MONUMENT SMALL ENGINE STORAGE SITE DEVELOPMENT PLAN

WITHIN A PART OF THE NORTHEAST QUARTER, SECTION 15,
TOWNSHIP 11 SOUTH, RANGE 67 WEST OF THE 6TH P.M.
COUNTY OF EL PASO, STATE OF COLORADO

Markup Summary

SD1

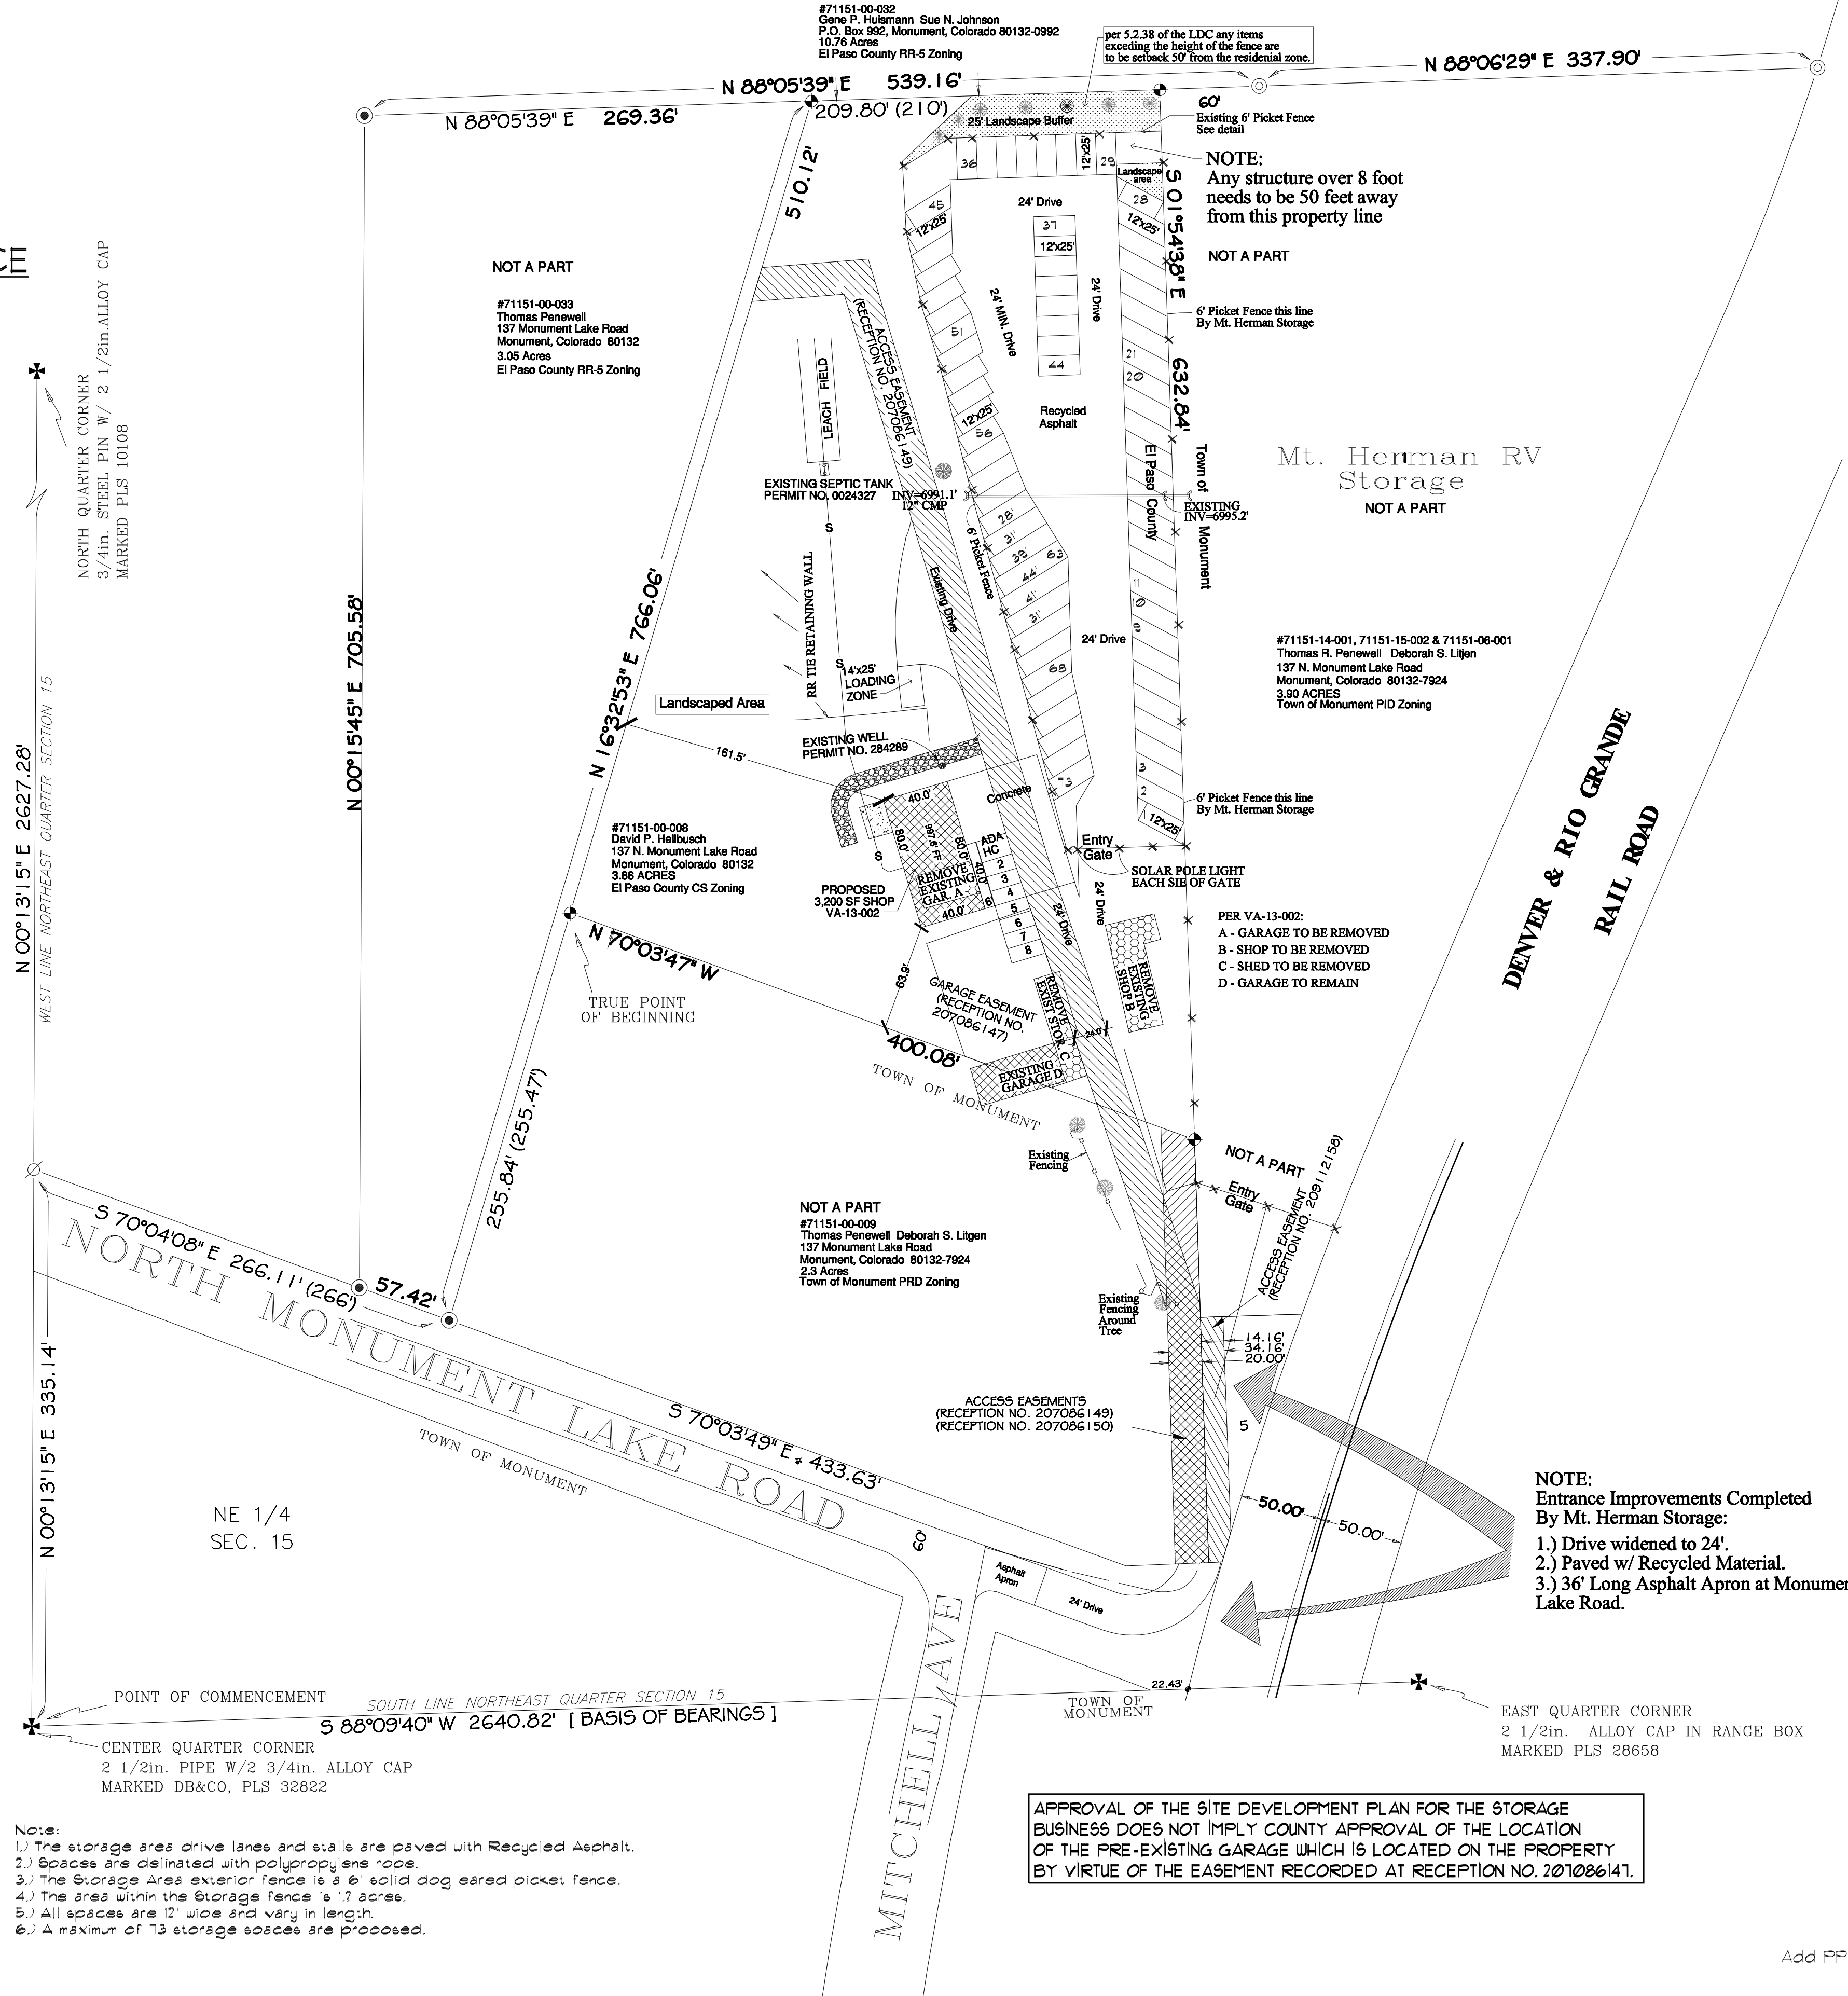
Must include the ADA accessibility route on the site plan from the ADA HC parking space to the structure. Include the path in the legend.

Mark the height of this fence and if it is the same fence that surrounds the site. Is this only for the northern fence?

If the height of the structures are 8 feet, and the fence is 6 feet, these structures need to be 50 feet away from this property line.

If this easement is not in use it should be vacated. Structures should not be placed over easements.

These are contradictory
